From: richard sinclair <[REDACTED]>
Sent: 02 February 2015 14:22
To: Daun Johnson
Subject: Re: AW/21/15/TC

Hi just to confirm that all the trees in the above application stand within the boundaries of
72 The Fairway, Aldwick Bay Estate, Bognor Regis, West Sussex and the applicant is the owner of these trees.

THE FAIRWAY

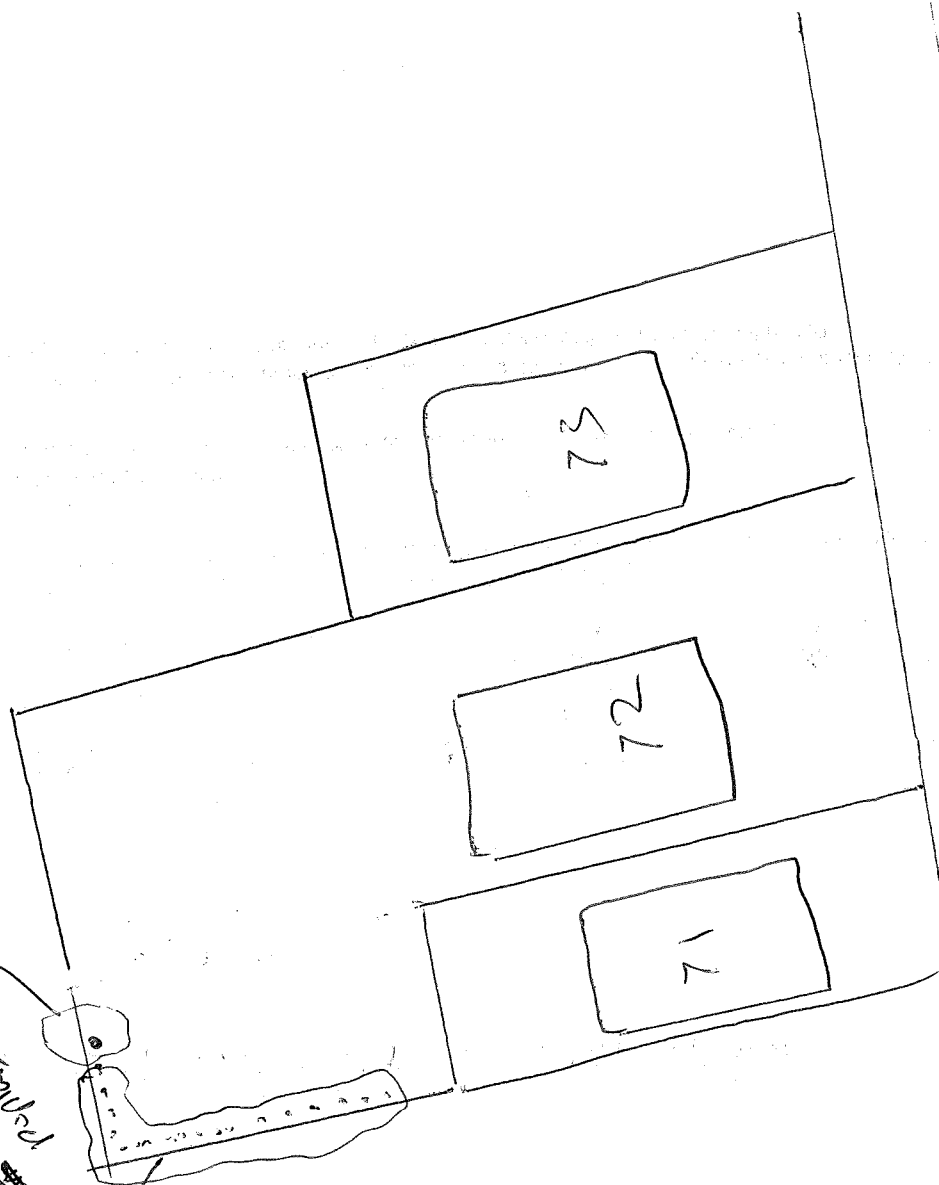
Can you please draw another plan showing the correct boundaries so there is no confusion on anyone's part as to the location of the tree?

The sketch you provided shows the trees being in the rear garden of 71 The Fairway.

If you would give me permission, I can tipex over the line causing the confusion and validate the application.

Hi , yes sorry I drew a boundary line in the wrong place , but the garden of 72 cuts in behind 71 !!
